<b>Application Ref:</b>	3/2025/0815			 Ribble Valley Borough Council www.ribblevalley.gov.uk
<b>Date Inspected:</b>	N/A	<b>Site Notice:</b>	N/A	
<b>Officer:</b>	EP			
<b>DELEGATED ITEM FILE REPORT:</b>				<b>APPROVAL</b>

<b>Development Description:</b>	Prior notification for proposed single storey rear extension with flat roof under Part 1 Class A of the GPDO. 4m long, 3m high (max) to ridge and 2.9m high to eaves.
<b>Site Address/Location:</b>	88 Mitton Road Whalley Clitheroe BB7 9JN.

Drawing file: planx_downloads / 25_0815_02_Proposed_Plans.pdf

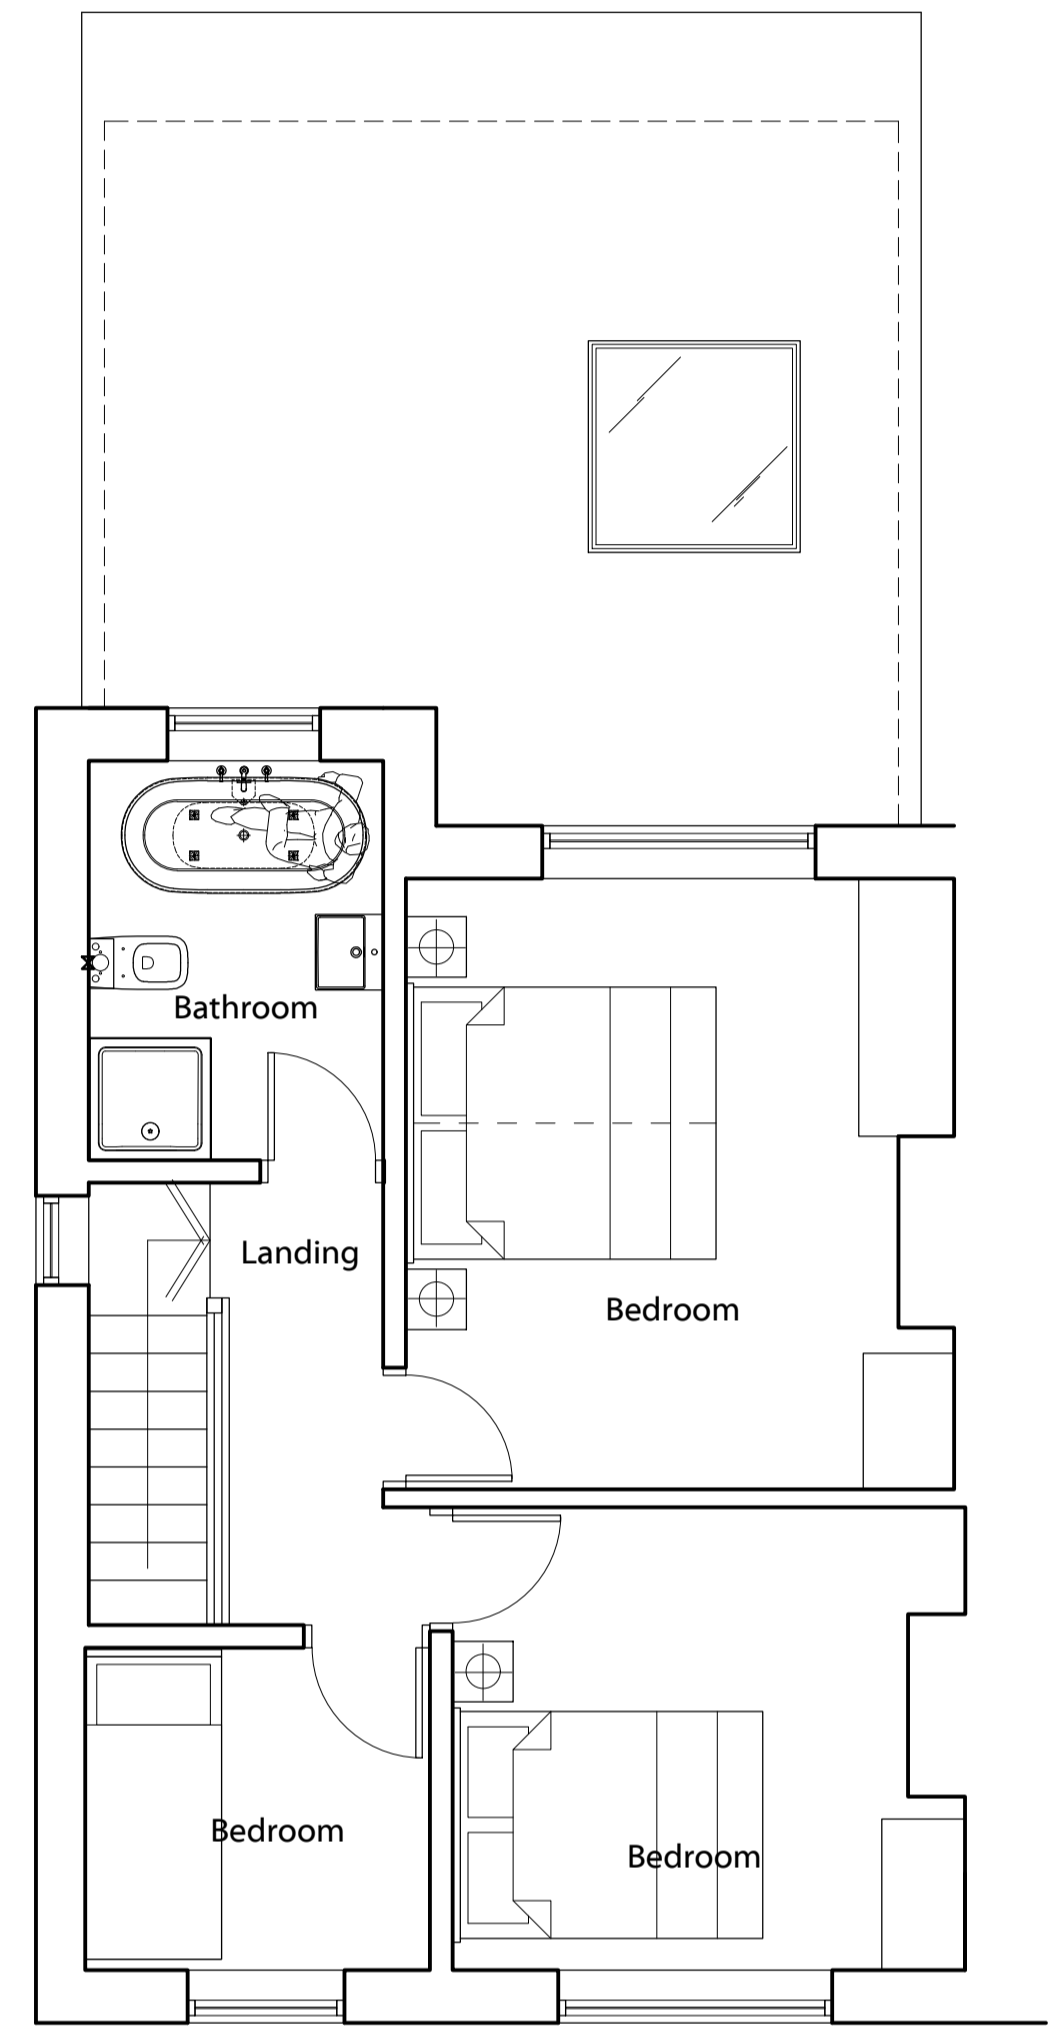
**The height of the proposed extension would not exceed the height of the existing dwelling.**

**The height of the eaves of the proposed extension would not exceed the height of the eaves of the existing dwellinghouse.**

**The proposed single storey extension would extend beyond the rear wall of the original dwellinghouse by 4.66 metres and measure 2.8 metres in height.**

**The proposed single storey extension would be sited within 2 metres of the boundary of the curtilage but will measure approximately 2.6 metres in height to the eaves.**

**The proposed materials are render to the elevations to match the existing dwelling.**
